Our Ref: 05C100062
Your Ref: 2021/62/93674/W

Non-Material Amendment (Condition 23) to full planning permission 2021/62/93674/W for partial redevelopment of Greenhead College including demolition and making good, erection of 2 and 4 storey buildings, reconfiguration of parking and access arrangements, reconfiguration of sports provision and other associated external works (within a conservation area) at Greenhead College, Greenhead Road, Huddersfield, HD1 4ES

Dwg. No.	NE8659- OOB- ZZ- 00- DR- L- 0001	Scale	1 : 500 @ A2
Revision	P31	Date	February 2021

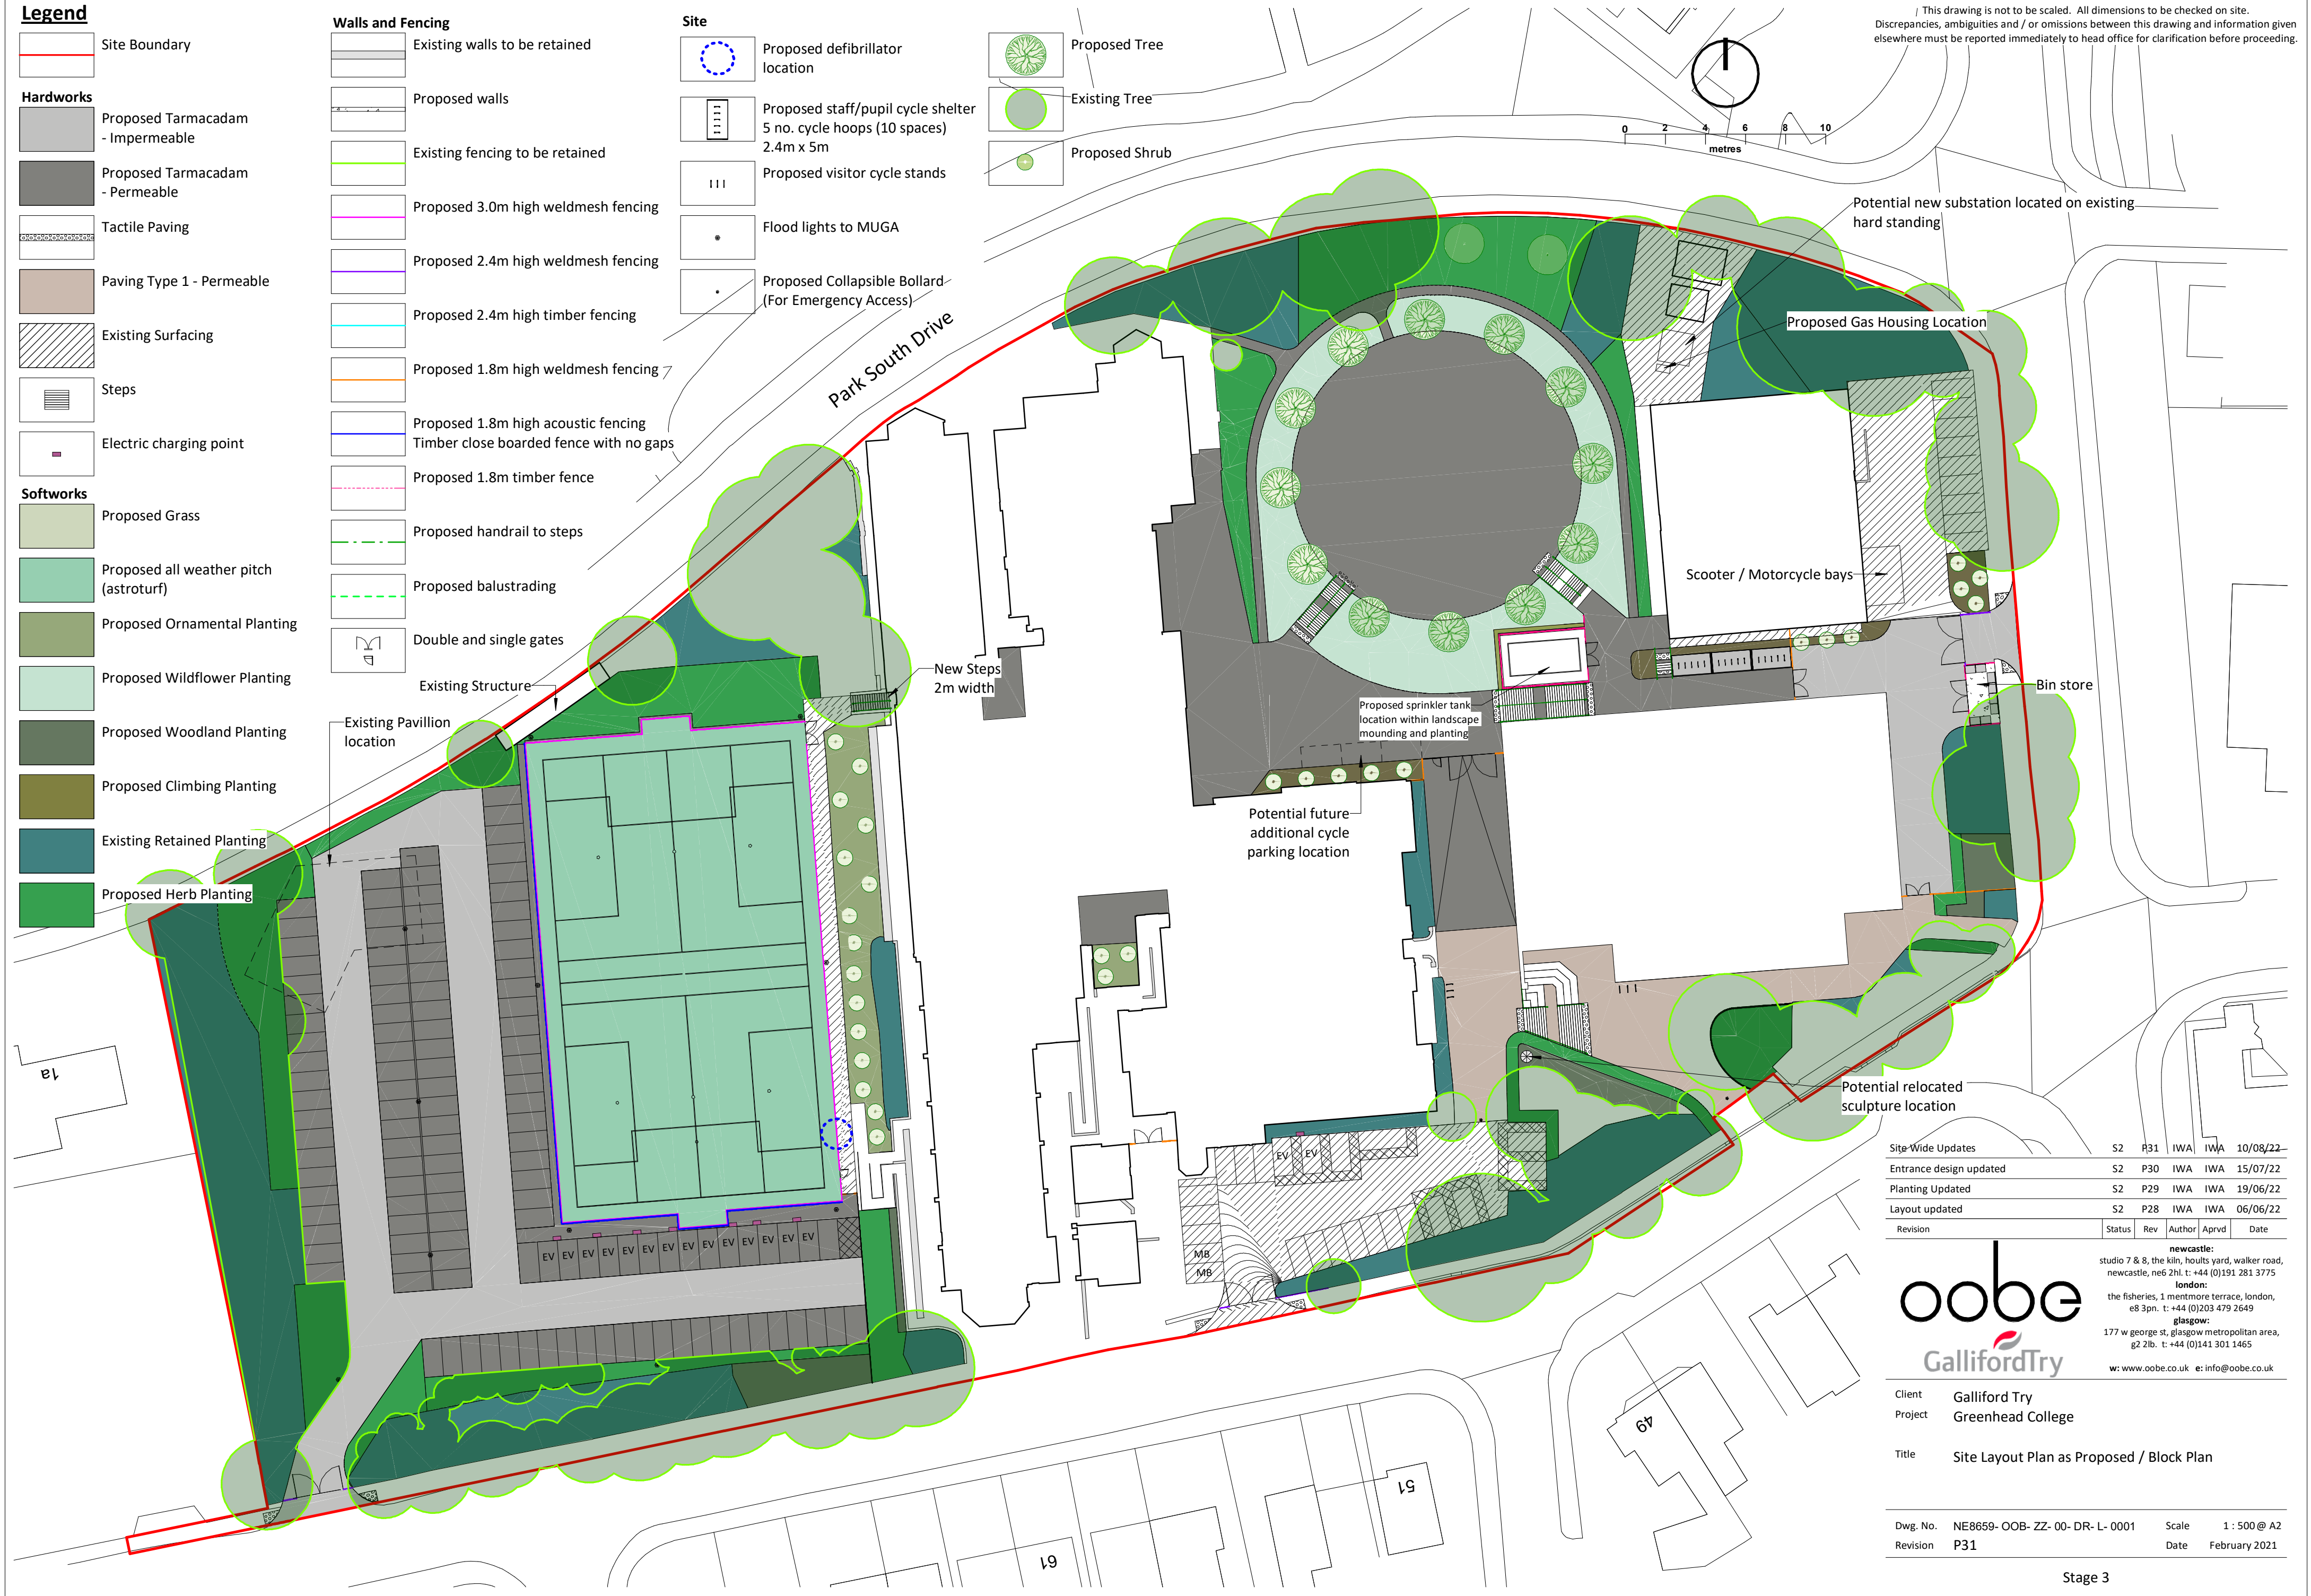
Prior to the ~~hereby approved 'new main build'~~, completion of the development as shown on plan ref. ~~'NE8659-RYD-01-ZZ-DR-A-3600 rev. P8', NE8659-OOB-ZZ-00-DR-L-0001- Rev P31 being brought into use,~~ the dedicated facilities that will be provided for charging electric vehicles as shown on plan ref. 'NE8659-OOB- ZZ- 00- DR- L- 0001 Rev. P25' shall be installed and made operational in accordance with those details in the PodPoint T3 | T7 | T11 | T22 Datasheet. Once installed the charging points shall be retained and maintained thereafter.

This amendment is required due to insufficient power requirements/obsolete breakers within the existing building sub-panel. This has resulted in Imtech only being able to provide power for 1no of the 7no EV Chargers adjacent to the MUGA pitch prior to the new main build being brought into use. The remaining 6no EV Chargers will be online for the end of phase 4. This is estimated to be in April 2025. The EV charging point for the accessible spaces adjacent to the building is unaffected

and will be installed along with one charge point adjacent to the MUGA before handover of the current phase.
